Erection of extension to medical centre

R/207/09

Amendment to internal layout to provide for pharmacy

REVISION D - 20/09/2010 - INTERNAL LAYOUT AMENDED TO SHOW PHARMACY
 REVISION C - 19/09/2008 - INTERNAL LAYOUT AMENDED TO SHOW PHARMACY
 REVISION B - 04/01/2007 - AMENDED PLANNING DOCUMENT ENCLOSURE AT SIDE ENTRANCE ADDED
 REVISION A - 23/11/2006 - PLANNING DOCUMENT

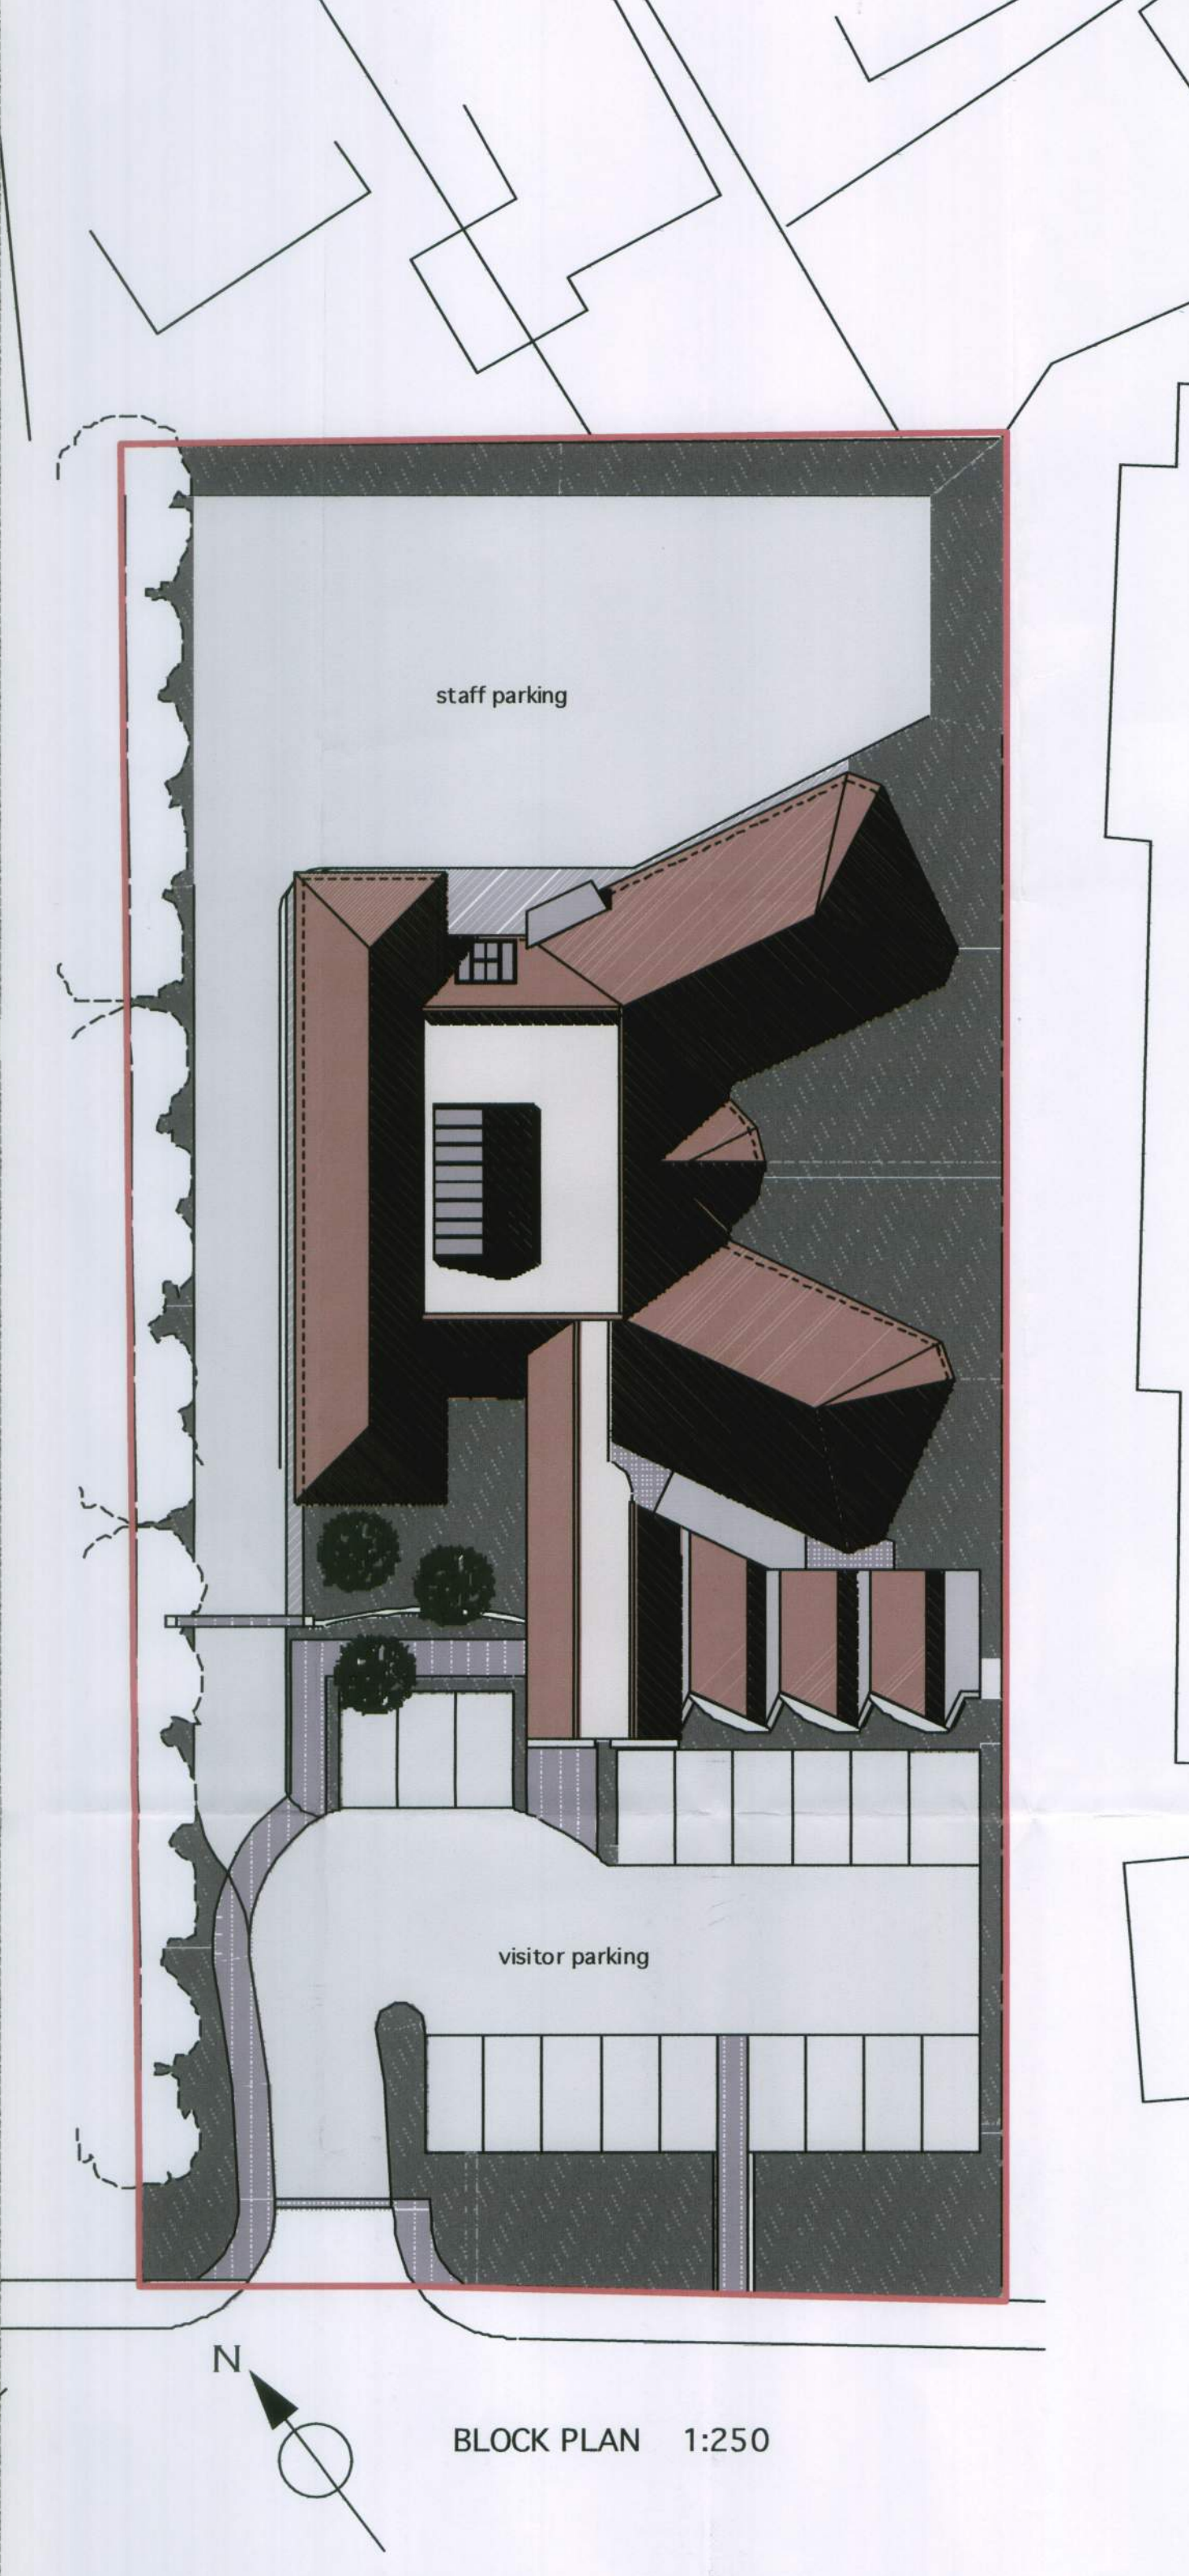
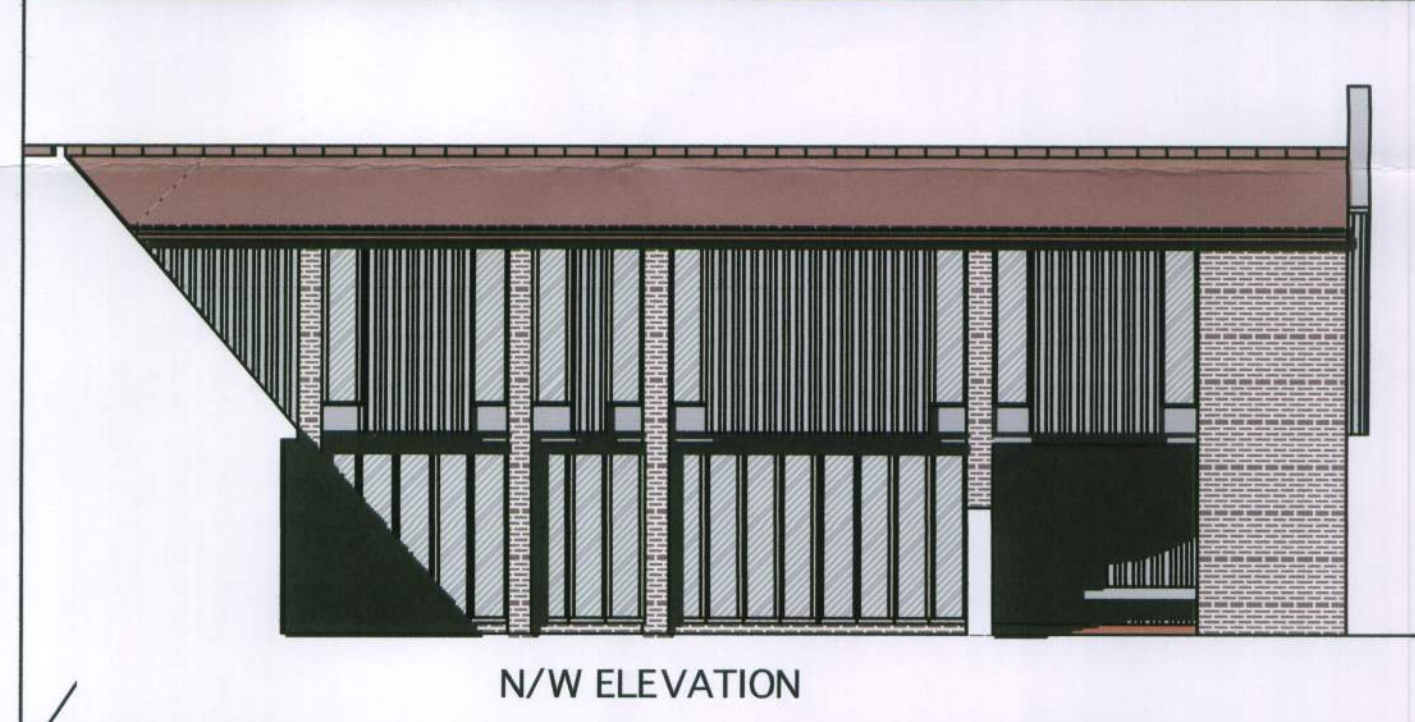
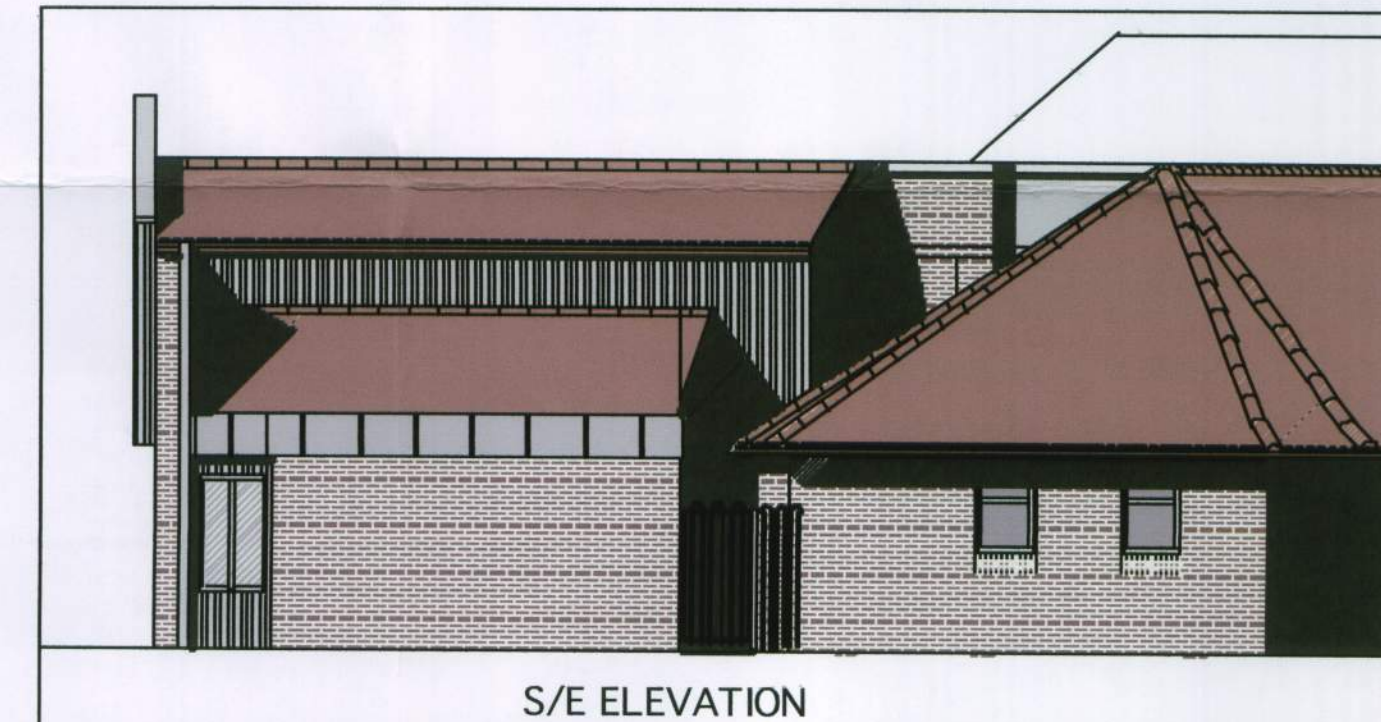
06.25/102B

06.25/102D
